Our ref: DOC22/632940
Your ref: SSD-8865-Mod 2

Subject: St Anthony of Padua Catholic School Redevelopment Modification 2, 125-165 Tenth Avenue and 140-170 Eleventh Avenue, Austral (SSD-8865-Mod 2)

Thank you for your e-mail received on 22 July 2022 requesting input from the Environment and Heritage Group (EHG) for the above modification application. The documents submitted with the application have been reviewed and comments are provided below.

**Figure 13** | Tree 496, proposed and revised sediment and erosion plan (Base source: Applicant's Modification Report and SRtS 2022)

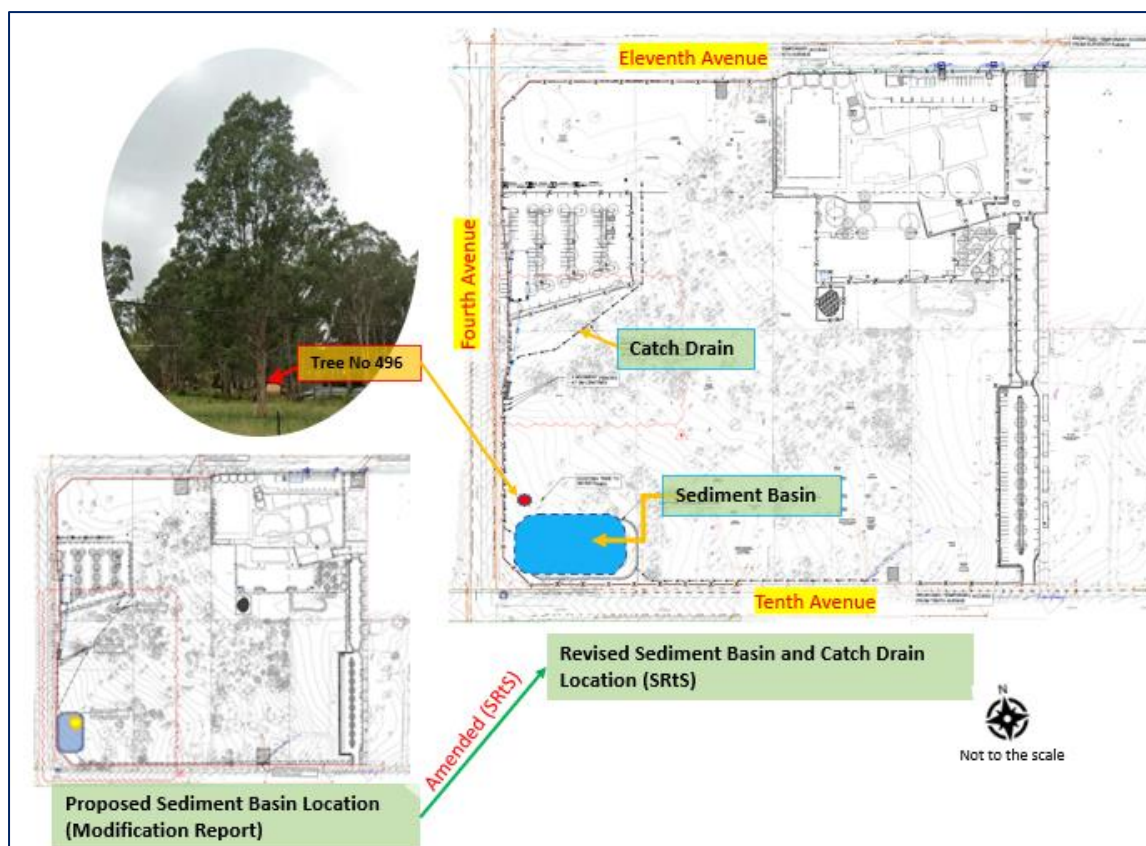
However, the Preliminary Sedimentation and Erosion Control Plan (PS&ECP) submitted with Modification 2 (Drawing No. C2.01 Issue 4 prepared by Warren Smith Consulting Engineers Pty Ltd dated 19/05/22) conflicts with the proposed retention of Tree 496. In this regard, it shows that a large sediment basin will be constructed in the area where Tree 496 is located. Further, the PS&ECP shows that a catch drain will be constructed that intersects the area of CPW that has been identified for retention.

EHG therefore recommends that the PS&ECP for the site is amended to:

- relocate the sediment basin away from Tree 496 and its associated tree protection zone (TPZ) so it can in fact be retained, and
- relocate the proposed catch drain so that it is located outside of the area of CPW identified for retention to reduce impacts to retained trees and CPW.

If, however, the catch drain cannot be relocated outside of the area of retained CPW further mitigation measures will be required such as constructing the catch drain by hand under the supervision of a suitability qualified arborist (Diploma in Arboriculture/AQF 5) with experience in the protection of trees on development sites. In addition, any disturbance to CPW should be rehabilitated as part of the landscape plan.
